From: Amber Willard
Sent: 11 December 2019 10:03
To: Planning Scanning
Subject: FW: Y/100/19/A

Y/100/19/A

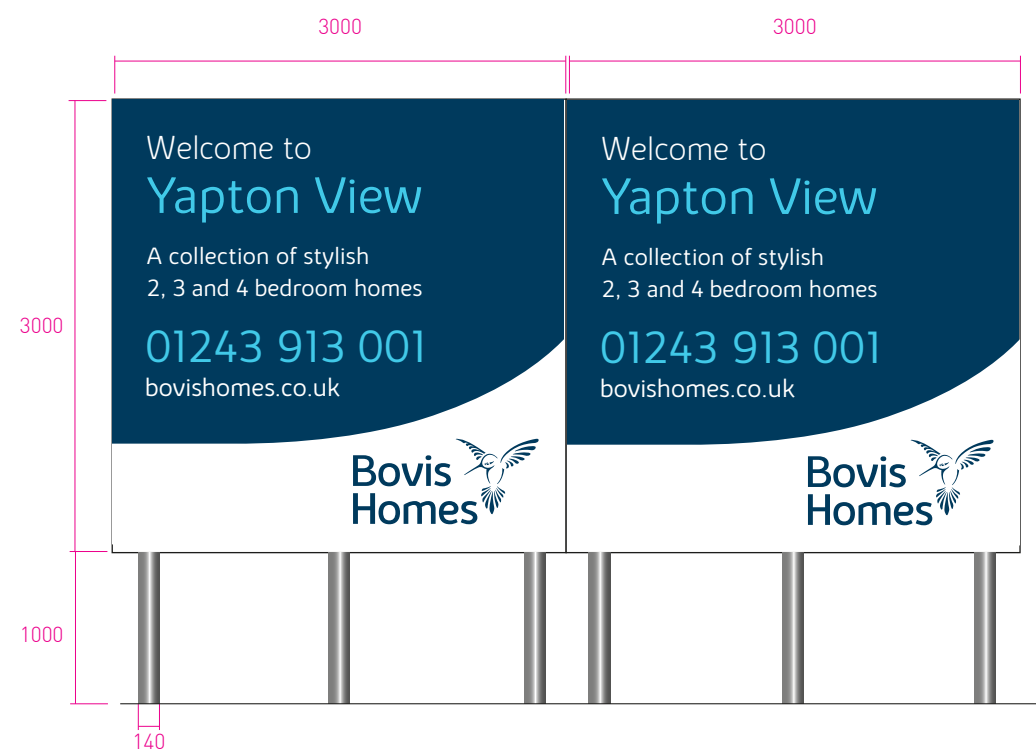
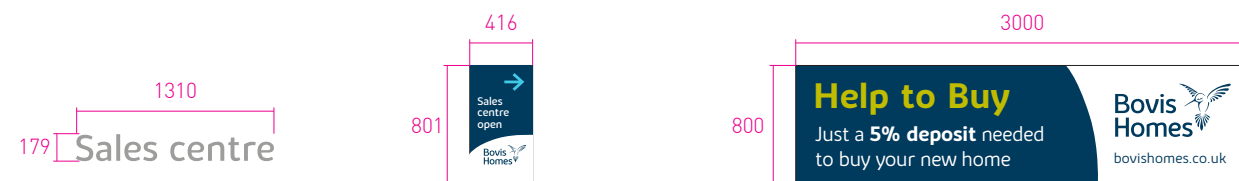
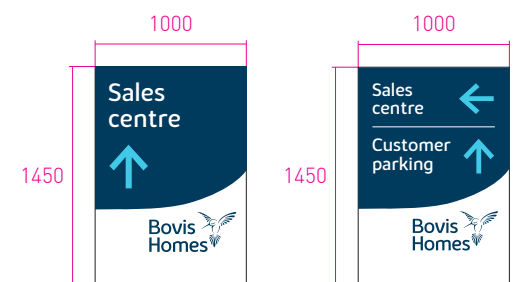
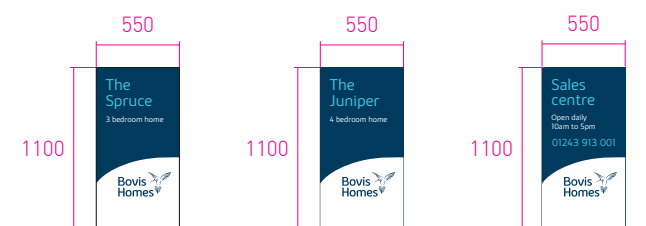
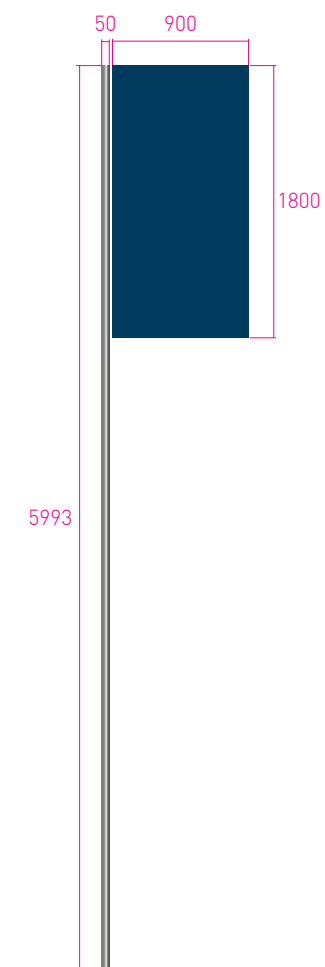
- I am unable to find K,L,O,M on the 'sales signage' Plan. Please are able to advise where they are on the plan or amend as necessary.
- The application states 2 fence panels and within the covering letter its states' two fence panels (items D and E). However on the 'sales signage' Plan, D is marked at 5 separate locations and E is marked twice. Please can you confirm if this means there will be 7 separate fence panels signs.

We have been advised by the applicant that item K is a movable sign that is stored away and only used on occasion so does not require advertisement consent. Please note that the applicant has decided not to install item L and therefore no longer forms part of the application. Item M is already marked out with the red dots on signage plan. Item O on the signage plan is plot markers and therefore does not require consent.

Item A – main totem V board x 1
Item B – medium totem x 1
Item C – medium totem x 1
Item D – fence panels x 11
Item E – fence panels x 2
Item F – wall panels x 2
Item G – small totem x 1
Item H – small totem x 1
Item I – small totem x 1
Item J – ACM cut letters x 1
Item F – flags x 32
